Ribble Valley Borough Council  
Council Offices  
Church Walk,  
Clitheroe  
Lancashire  
BB7 2RA

Phone: 0300 123 6780  
Email: [developeras@lancashire.gov.uk](mailto:developeras@lancashire.gov.uk)  
Your ref: 3/2026/0099  
Our ref: 3/2026/0099/HDC/KW  
Date: 30 April 2026

**Location:** New Barn Knowles Brow Hurst Green BB7 9PT  
**Proposal:** Proposed conversion of agricultural barn to dwelling house. Works to include upgrading works to access and access track, creation of parking area, re-instatement of collapsed roof, insertion of rooflights and alterations to fenestration.  
**Grid Ref:** 369706 438564

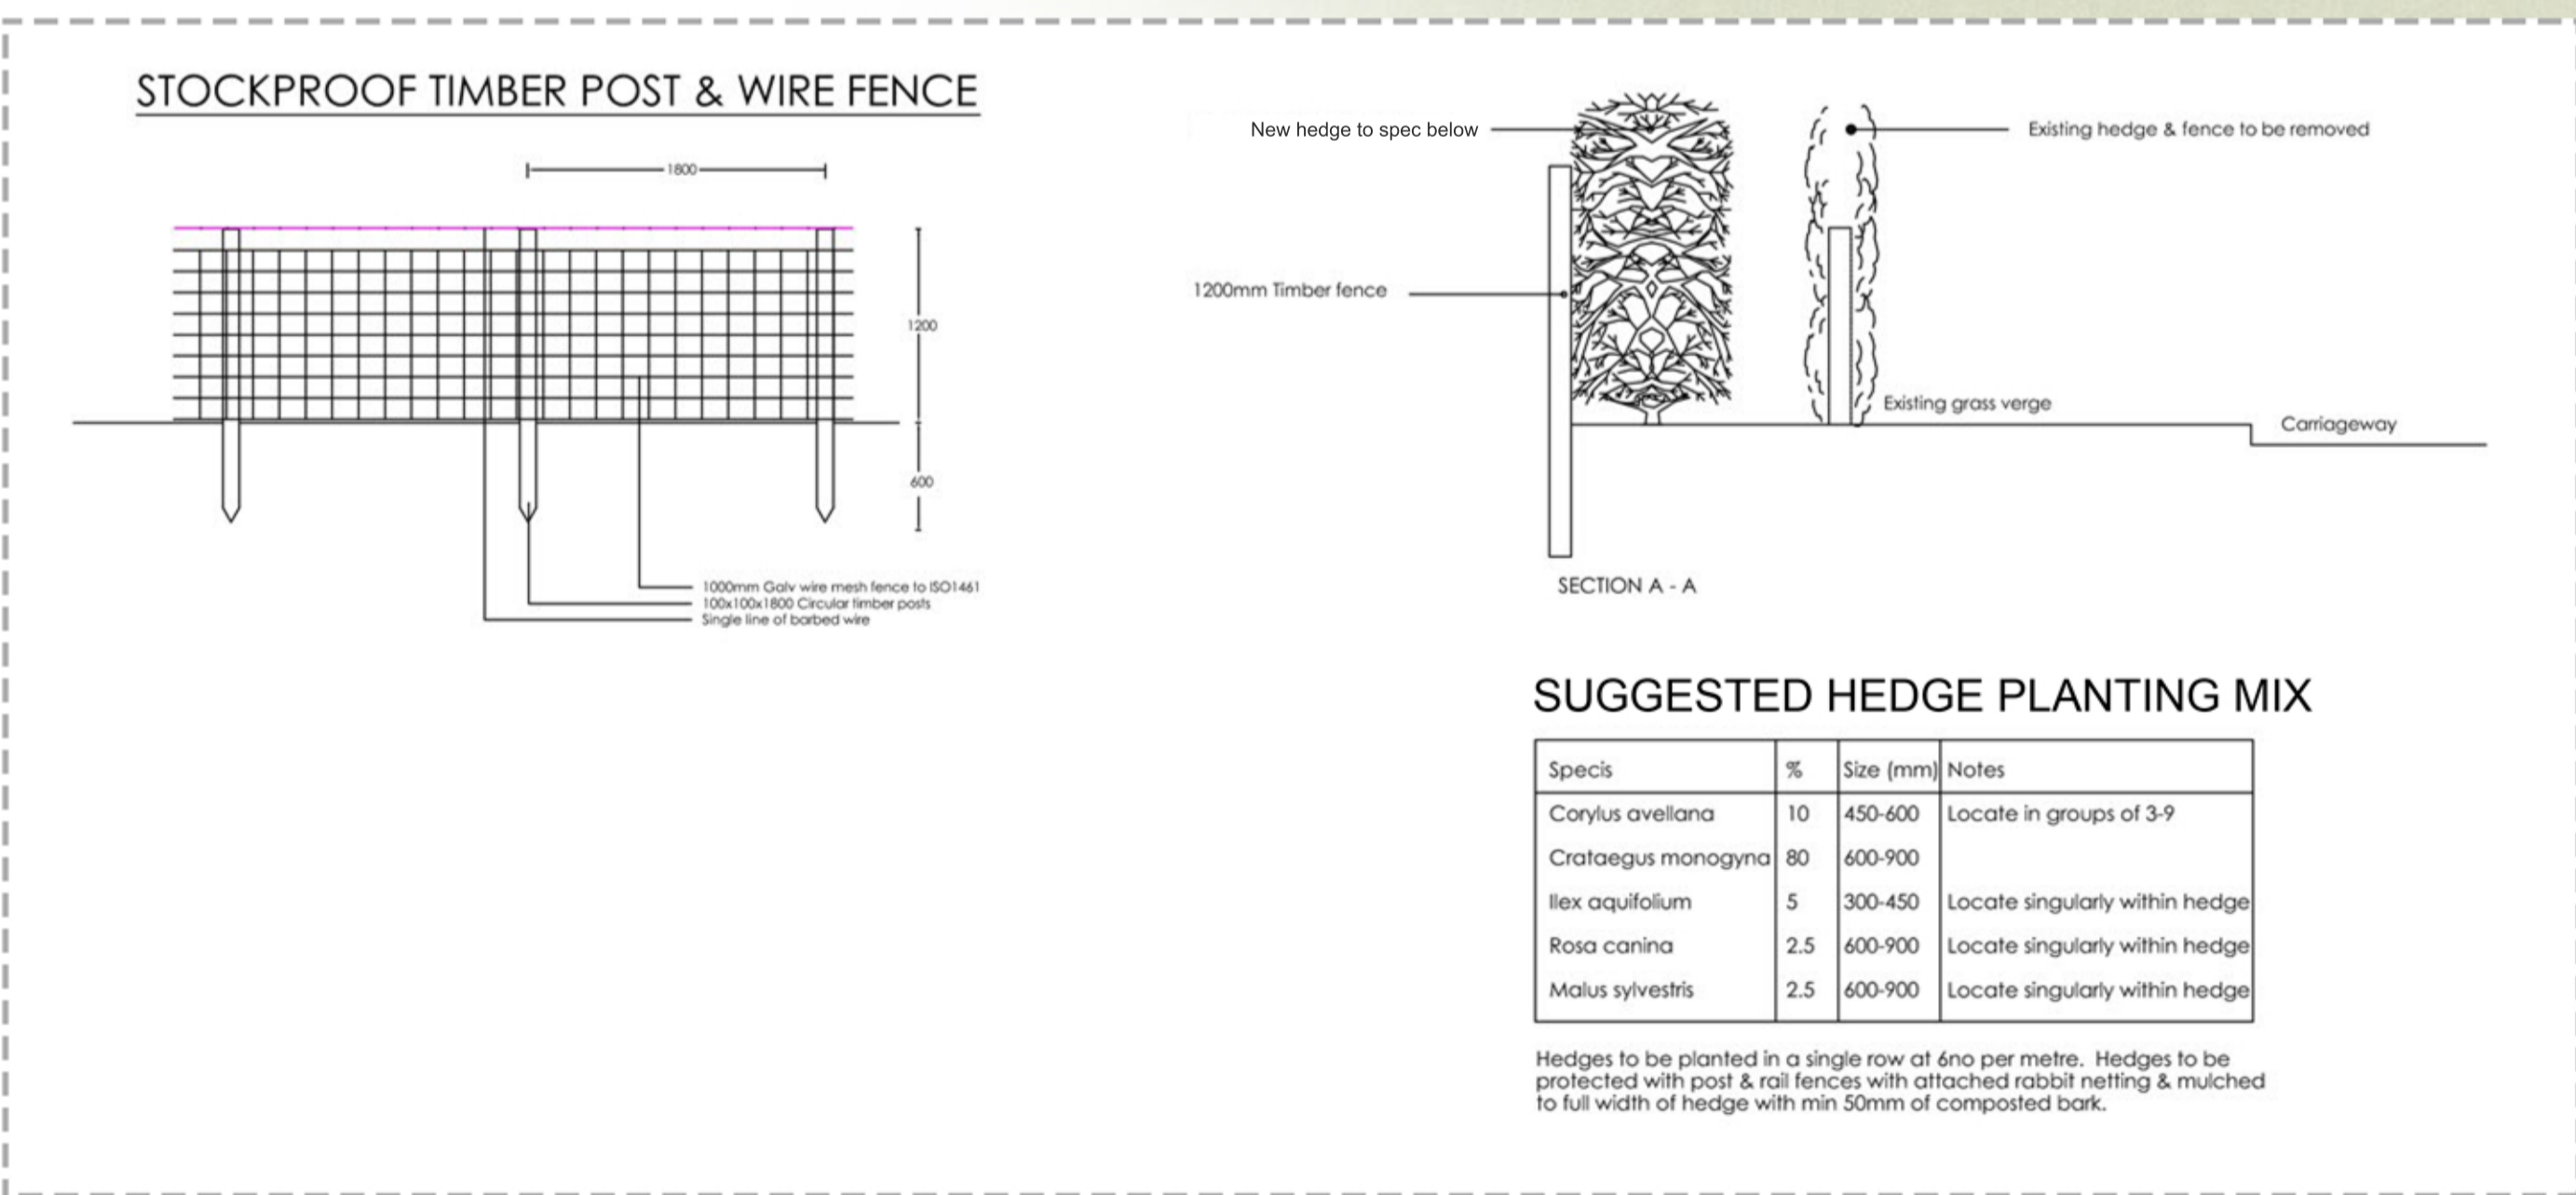
It is understood that some of the access improvements have already taken place. The proposal includes a 6m radius, 5.5m wide access for at least 10m into the site, as well as works to secure visibility splays along Whalley Road. The access put forward as shown within drawing 8857 – SK01\_A is acceptable to the LHA.

Access improvements also include a passing place along the shared private access road, which begins approximately 125m from the access to Whalley Road. The passing place widens the access road to 5.5m for at least 14m, which allows vehicles to pass each other, including agricultural vehicles.

The access point shall also be appropriately surfaced in a hardstanding material and feature surface water drainage to ensure water from the access and surrounding private land is not discharged onto the highway. The access improvement works will require the applicant to enter into an appropriate legal agreement with Lancashire County Council as the Highway Authority prior to the start of any development.

The surface water from the approved access onto Whalley Road should be collected within the site and drained to a suitable internal outfall.

2. No part of the development hereby permitted shall be occupied until such time as the access arrangements shown on drawing number 8857 – SK01\_A have been implemented in full.

**Reason:** To ensure that vehicles entering and leaving the site may pass each other clear of the highway, in a slow and controlled manner, in the interests of general highway safety and in accordance with the National Planning Policy Framework.
3. Prior to first occupation, the passing places a shown on plan, drawing number x8857 – SK01\_A shall be completed to a length of 14m providing a total width of 5.5m and hard paved.

4. No building shall be occupied until visibility splays 2.4 metres back from the centre line of the access and extending 120m in both directions along the nearside carriageway edge have been provided at the access, as shown on the approved plans. Nothing shall be erected, retained, planted and / or allowed to grow at or above a height of 0.9 metres above the nearside carriageway level which would obstruct the visibility splay. The visibility splays shall be maintained free of obstruction at all times thereafter for the lifetime of the development.

**Reason:** To ensure adequate inter-visibility between highway users at the street junction or site access, in the interests of highway safety.
5. Before the access is used for vehicular purposes, any gateposts erected at the access shall be positioned at least 10m behind the nearside edge of the highway. The gates shall open away from the highway.

6. Before the access is used for vehicular purposes, that part of the access extending from the highway boundary for a minimum distance of at least 10m into the site shall be appropriately paved in tarmacadam, concrete, block pavements, or other hard material to be approved by the Local Planning Authority.

**Reason:** To prevent loose surface material from being carried on to the public highway thus causing a potential source of danger to road users.
7. The surface water from the approved access shall be collected within the site and drained to a suitable internal outfall. Prior to commencement of the development details of the drainage strategy shall be submitted to and approved in writing by the Local Planning Authority. The scheme shall be implemented in accordance with the approved details.
